**From:** Harry Chalk  
**Sent:** 10 June 2025 10:53  
**To:** Planning Scanning  
**Subject:** FW: BR/65/25/PL - New Barn Garage

Sorry for the quick follow-up, but could I query the parking provisions laid out to the rear of the site? I note there are three bays, but these seem inconsistently depicted between the site and floor plans, and I am not clear that one of the bays fits within the red edge shown on the location plan. Could you take a look and come back to me by 06/06/25?

Dwg No. **24004A-P-013**

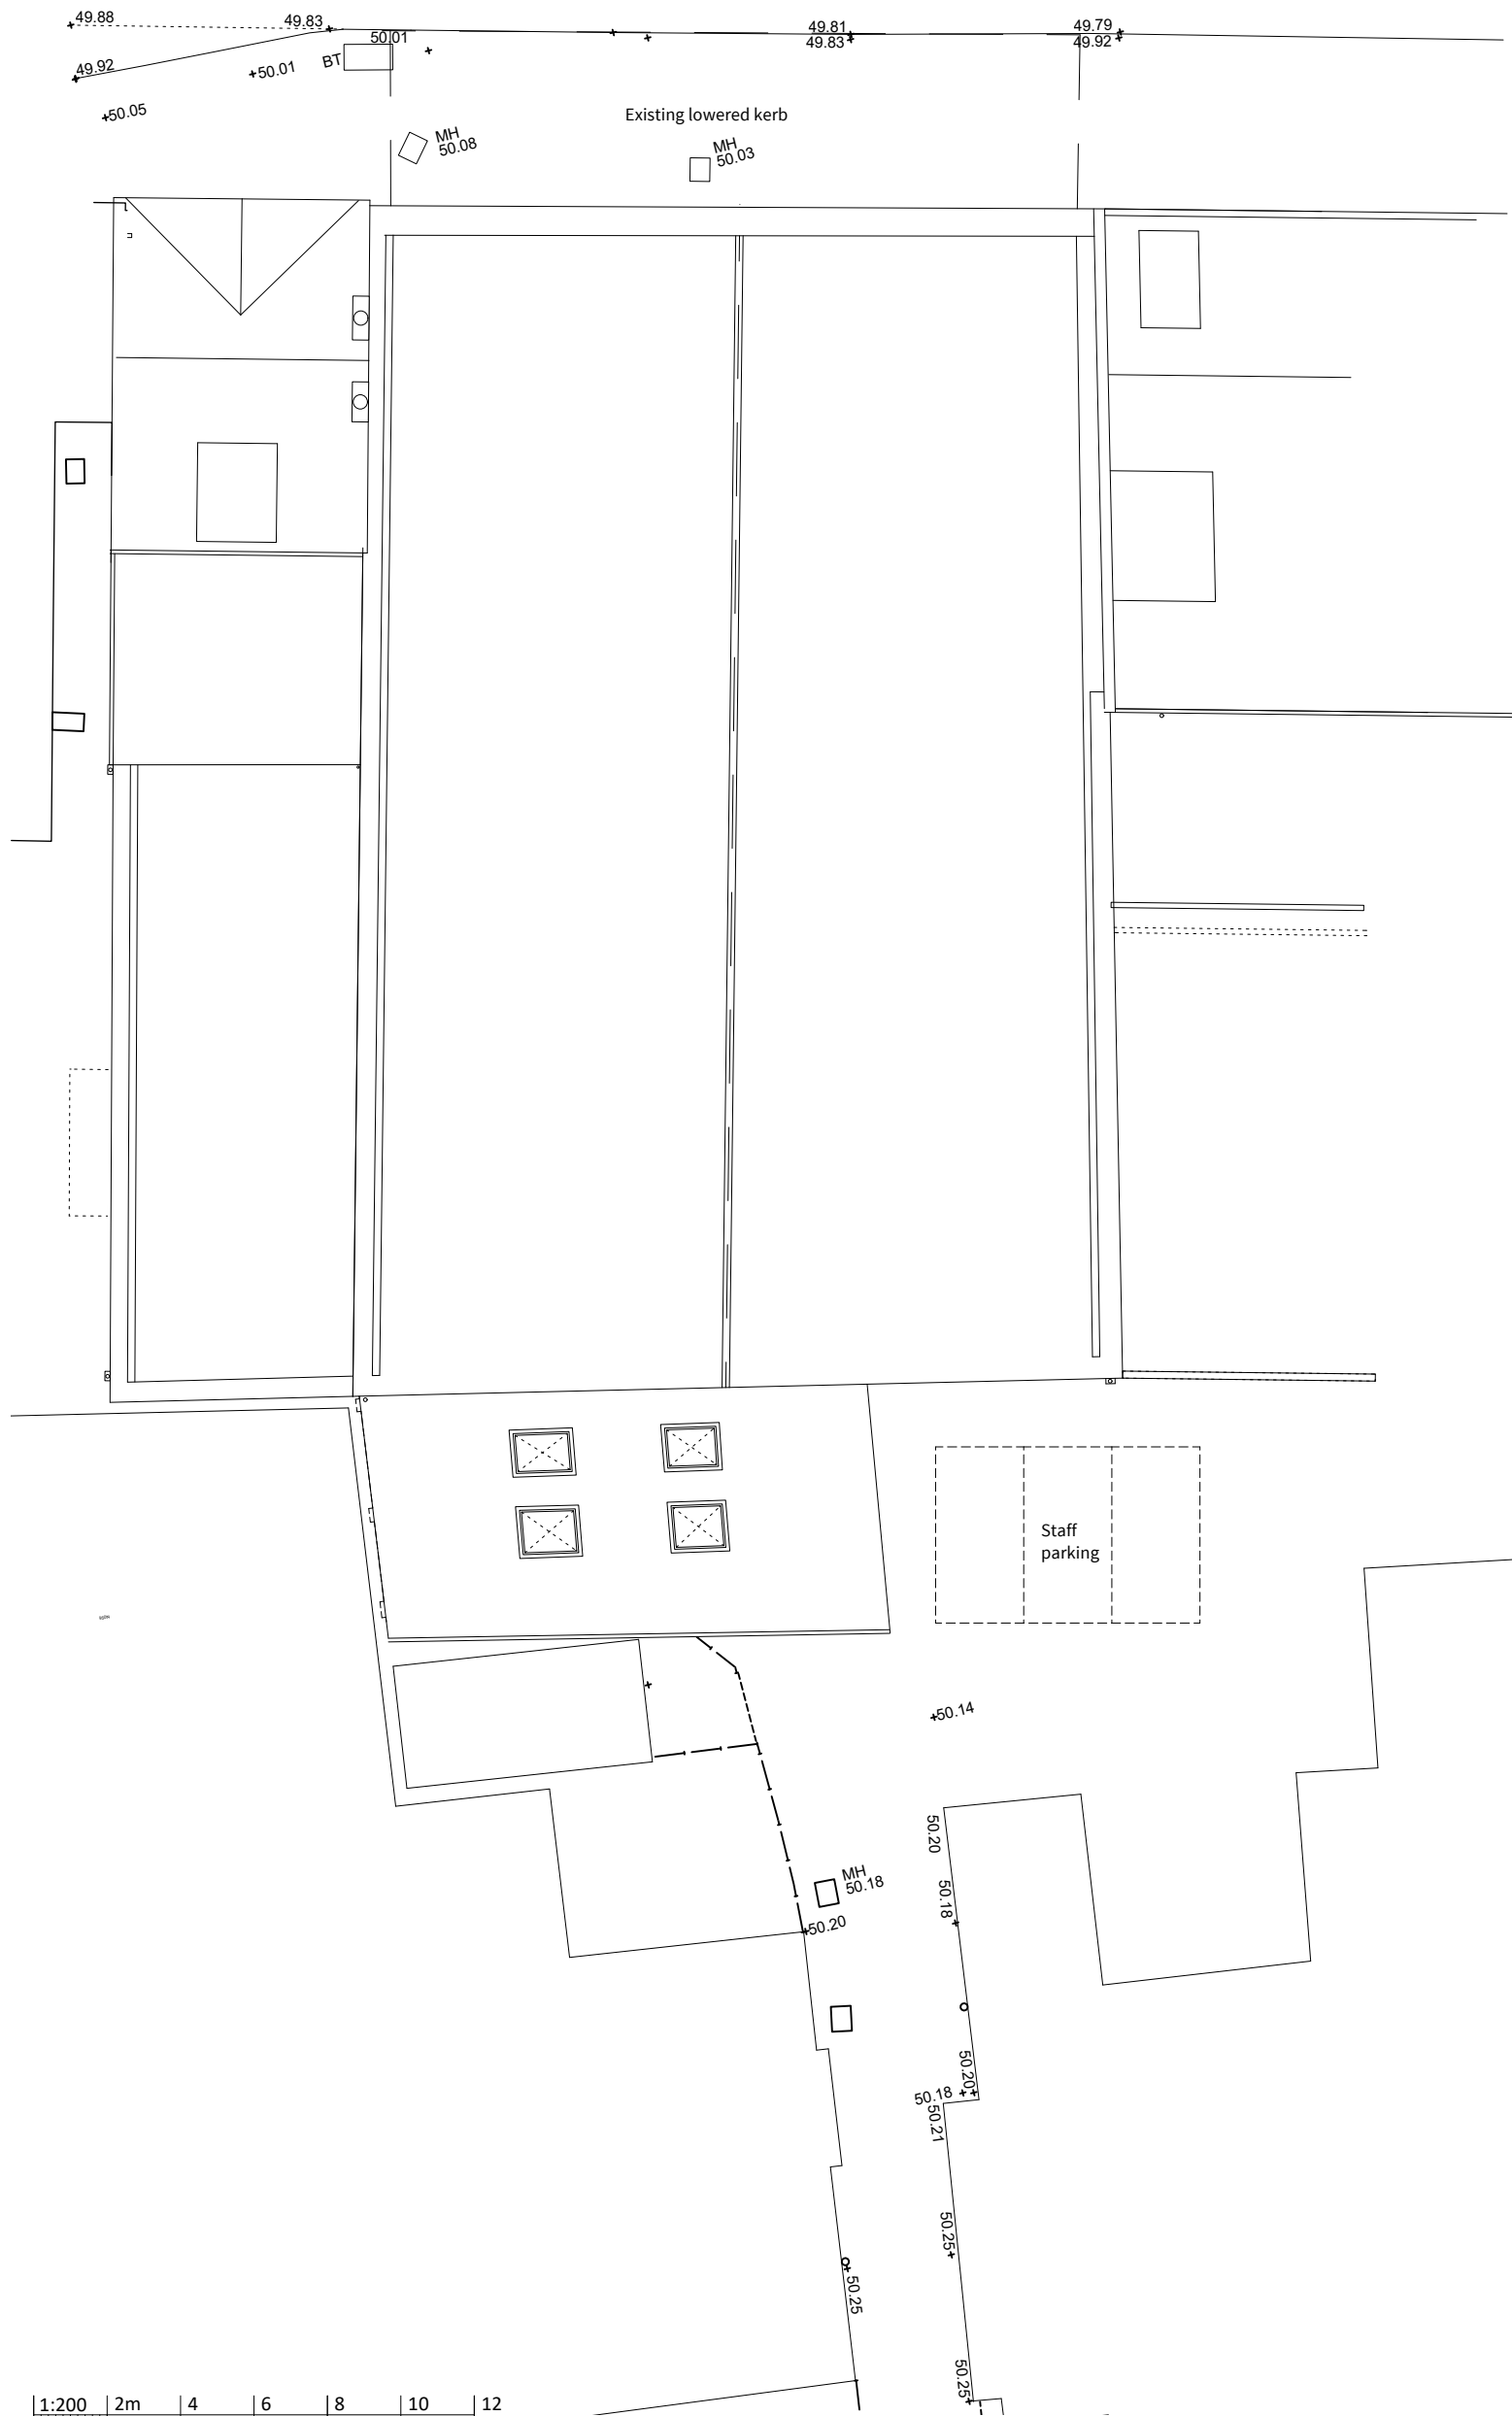
Thank you for sending this through. Please also amend the proposed site plan to ensure consistency between the plans. Can I ask that this is provided by 10/06/25?

Please find the site plan attached.

Thank you for your email. You are correct the spaces were shown beyond the line. Please find the corrected drawing attached.
